1.1 This is the Written Representation of Fen Ditton Parish Council in response to the proposed relocation of Cambridge Waste Water Treatment Plant ('CWWTP'). It expands on the issues raised in our Relevant Representation (RR-006) and points raised at Open Floor Hearing 1 and Issue specific Hearings 1 and 2.

## 2 Summary (from OFH1, EV-003a)

Figure S.1: Initial Options

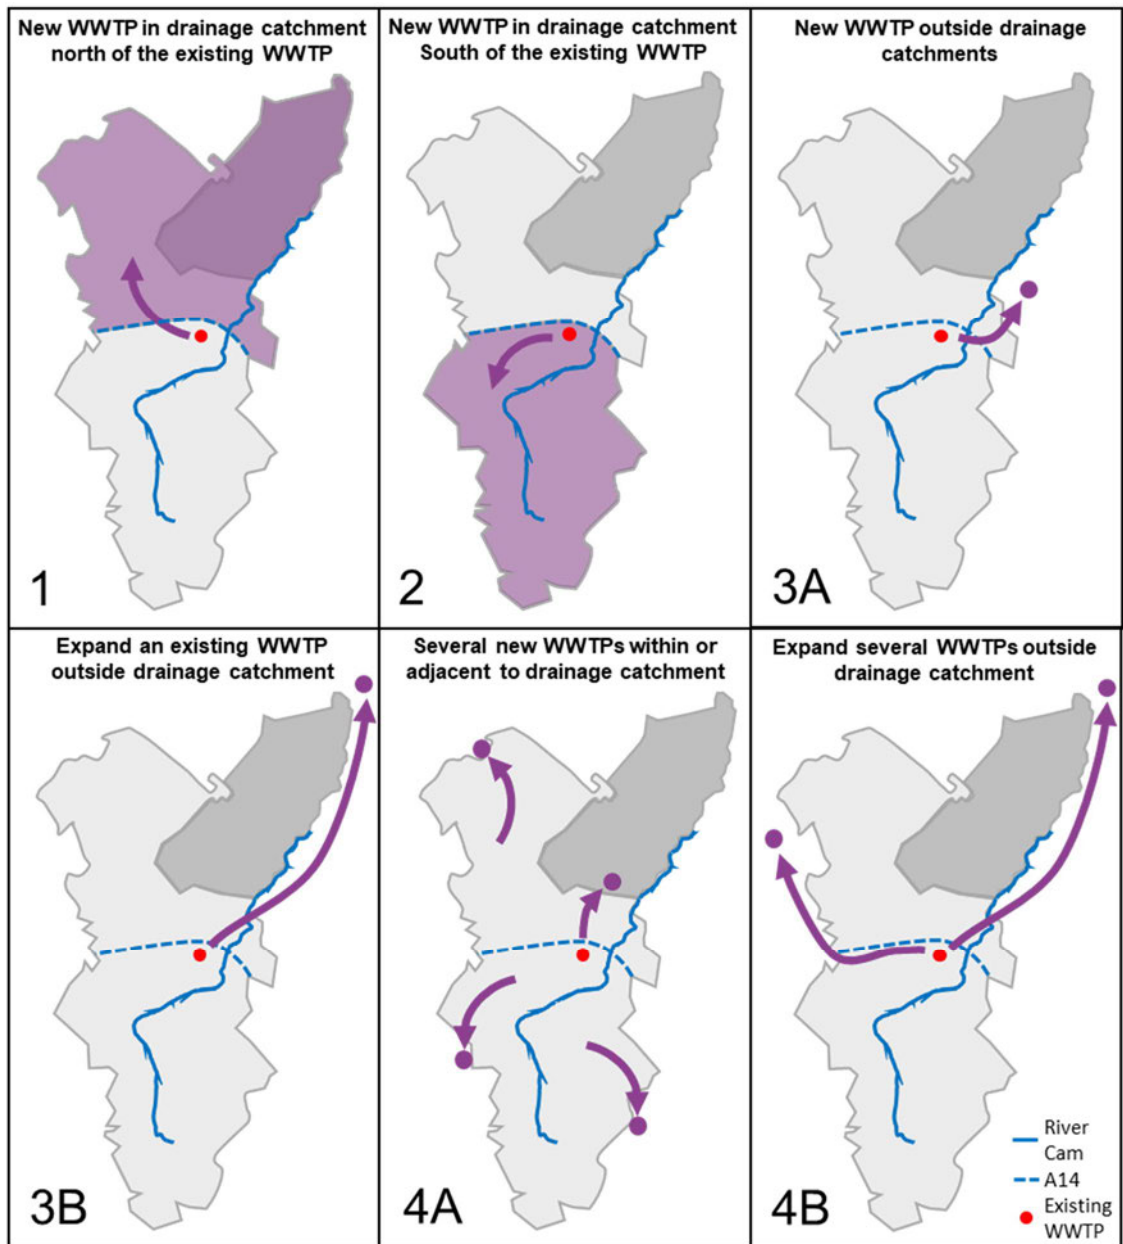
- ii) The evaluation of alternatives is incomplete and, possibly, skewed towards Site 3. The option to stay on site should be considered not least because of the avoidance of capital carbon, which otherwise adds to the climate emergency, and operational carbon due to increased pumping. In addition, staying on site would bring a proper return on the mid-2010s, c.£20million investment in the "D" works which we believe was funded by Anglian Water's customers. Anglian Water should confirm if the evaluation of alternatives to Site 3 considered:

- the use of intermediate pumping to lessen the depth of tunnelling to minimise any construction in the lower aquifer;
  - the possibility of tunnelling directly under the Science Park for sites west and north west of the existing Cambridge WRC Works instead of the tortuous route evaluated in the site selection stage; and

- use of a single thickness tunnel thickness lining rather than the assumed double lining where tunnels were expected to penetrate the lower aquifer. The latter point arising because exfiltration of sewage causing groundwater contamination cannot occur when the groundwater pressures are much higher in the aquifer than the fluid level inside the tunnel.
